**Albuquerque Studios Master Plan
Development**

Traffic Impact Study

September 13, 2021

The following two sections in the Executive Summary list agency comments received on the draft TIS submission along with responses provided for this final TIS.

Figure 13
Buildout With Project AM Peak Hour Volumes
23

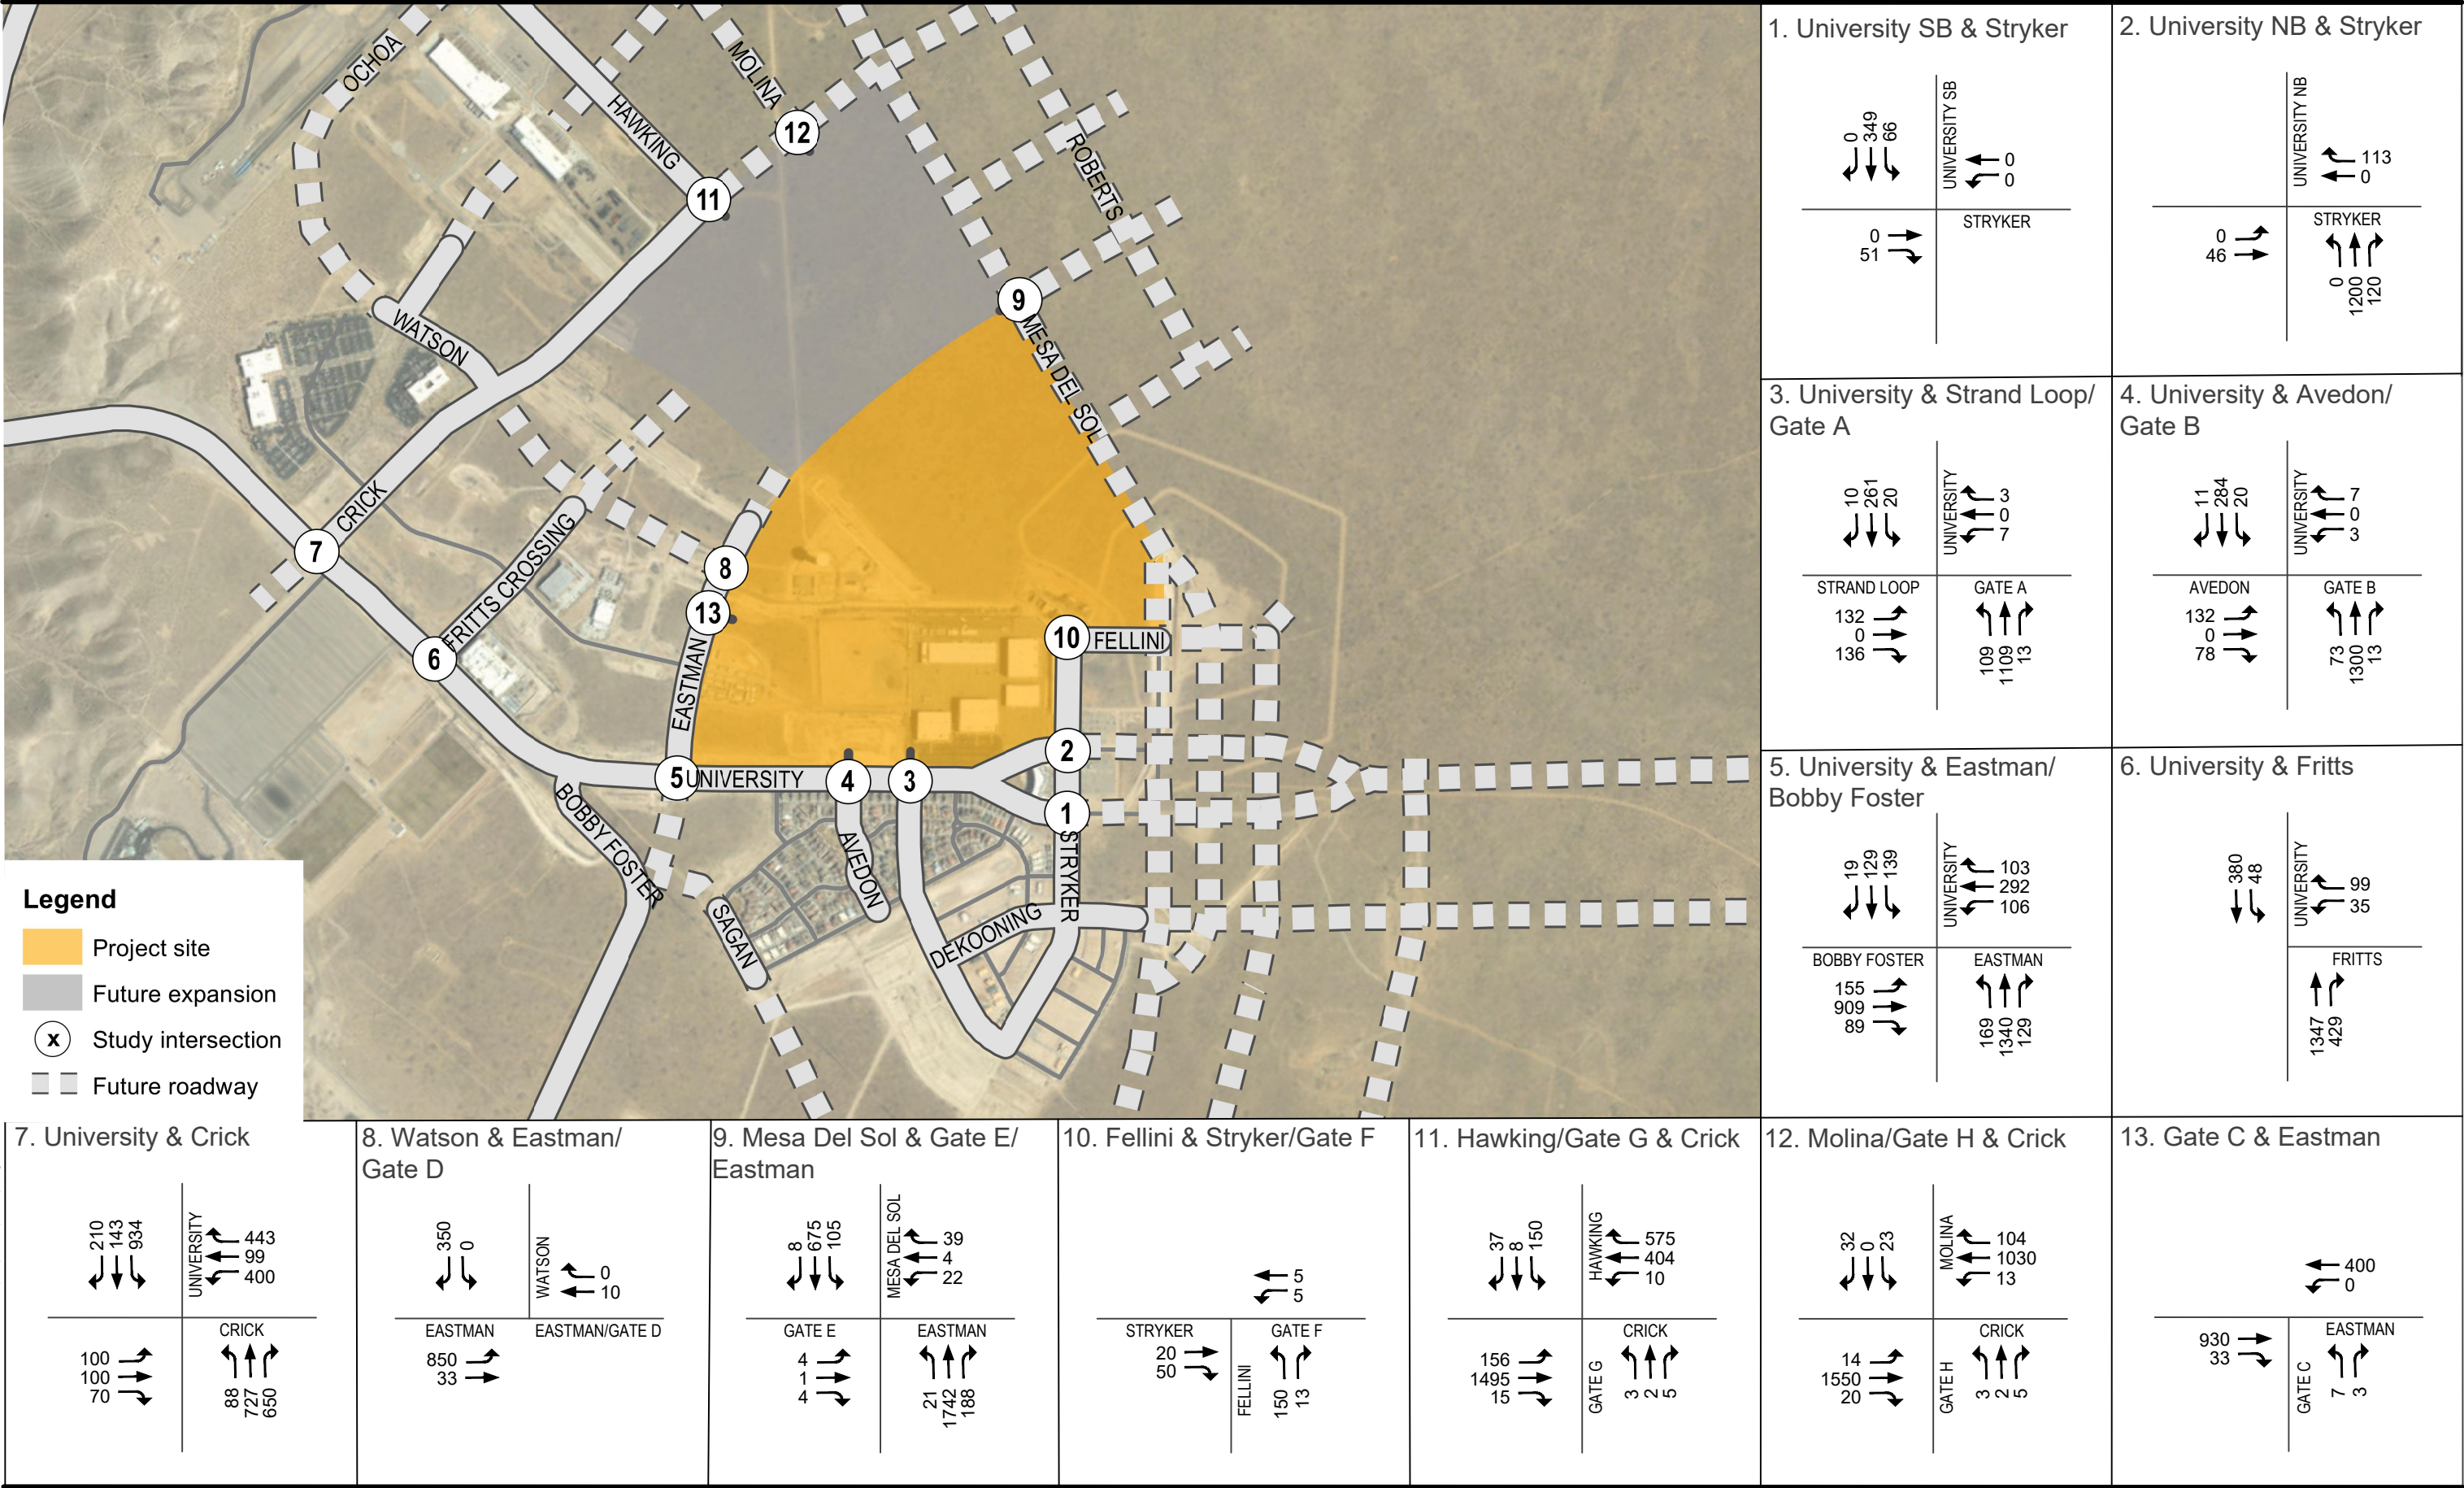
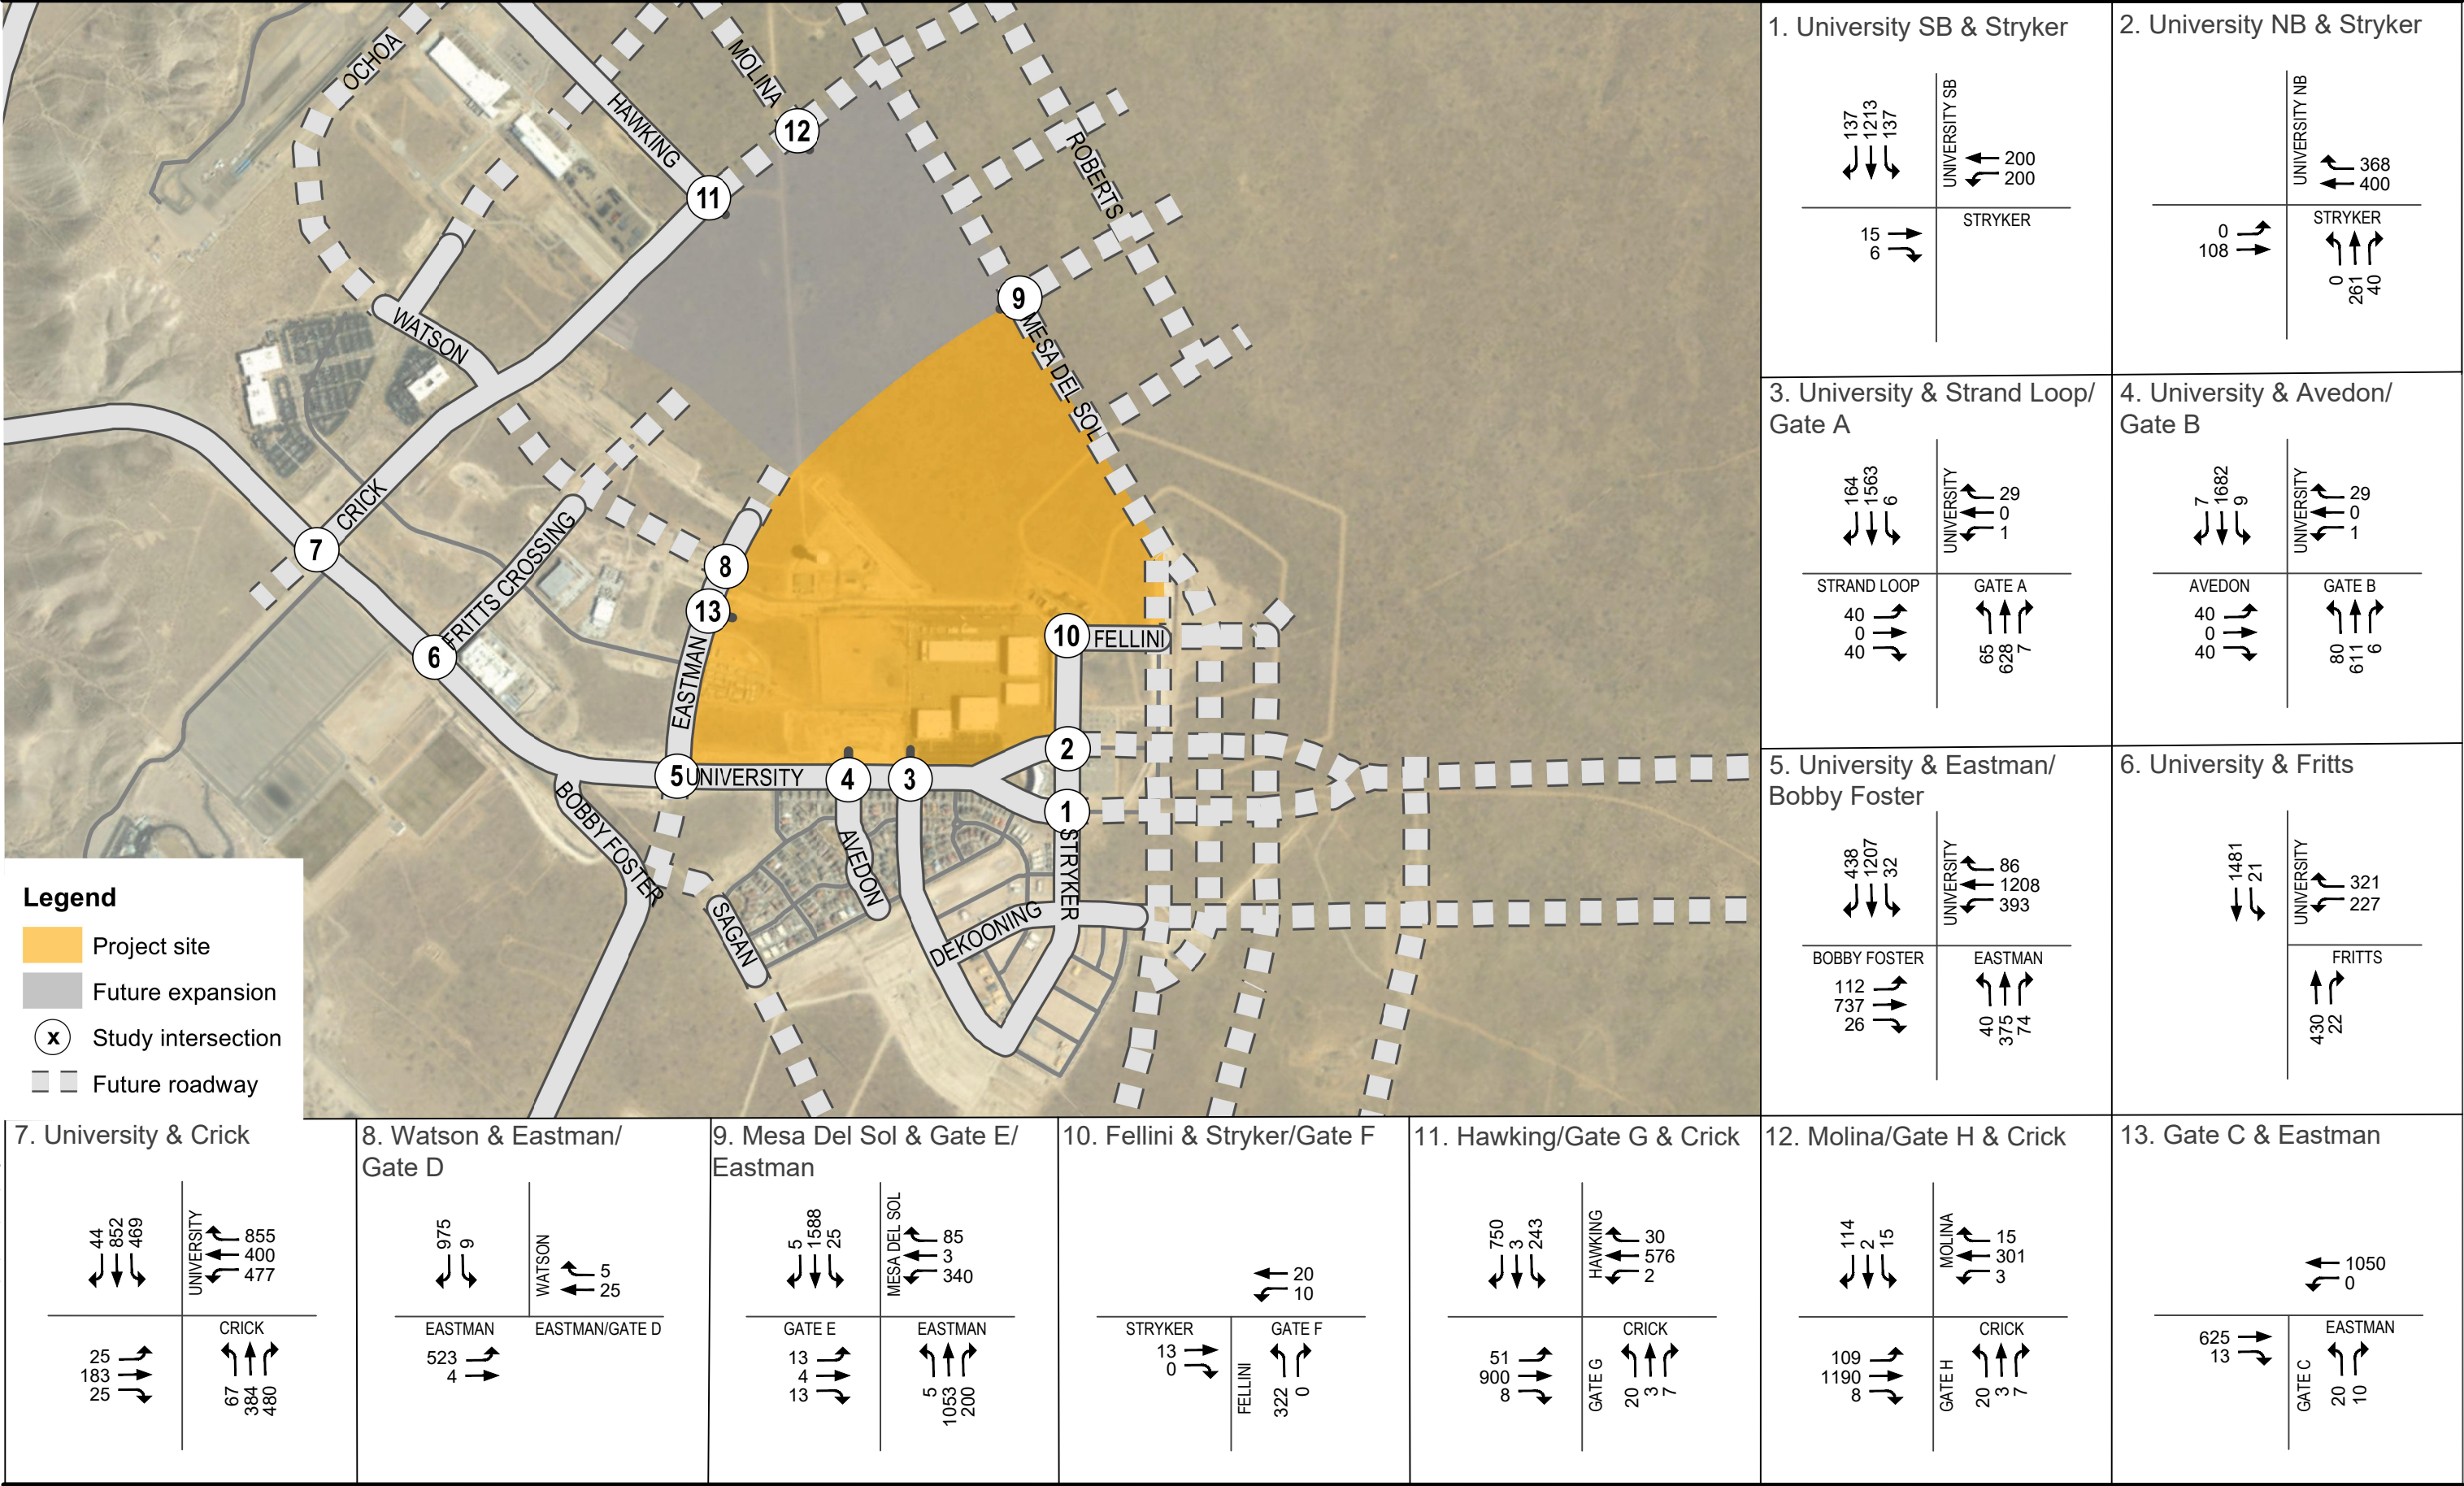
2. The trip distribution on Bobby Fosters Rd. is higher than expected. The Netflix buildout year traffic in the AM peak is 1,016 vehicles per hour (vph) eastbound and 218 vph westbound. The PM peak has 671 vph eastbound and the westbound direction has 1,523 vph. Bobby Foster does not have an interchange. The Mesa del Sol master plan committed to building the Mesa del Sol interchange. A majority of the Bobby Foster traffic should be shifted to University Blvd. As University Blvd. nears capacity the excess traffic should shifted to Mesa del Sol Blvd.

3. Provide a justification for the amount of traffic on Bobby Foster. The level of service will need to be evaluated for Bobby Foster.

This TIS used Trip Generation estimates provided by others for Montage for contributing traffic on Bobby Foster. ½ of the Montage development traffic was

forecasted to use Bobby Foster toward University. Of that, 70% was assigned to University/Bobby Foster and 15% each to Avedon/University and Strand Loop/University.

The traffic analyses conducted on Bobby Foster included access to and from the Montage Development. A review of the preliminary site plan was used to estimate the traffic described above for Bobby Foster. An LOS analysis was conducted for Bobby Foster/University and Eastman that included the traffic forecasts. The LOS is for Bobby Foster and University is forecasted at LOS B for the Implementation Year (2026) for both AM Peak Hour and PM Peak Hour (TIS, Pg. 28). The intersection is forecasted to be LOS D (for both AM and PM Peak Hour) for the Horizon Year Analysis Period (Level B Master Plan) (TIS Pg. 29).
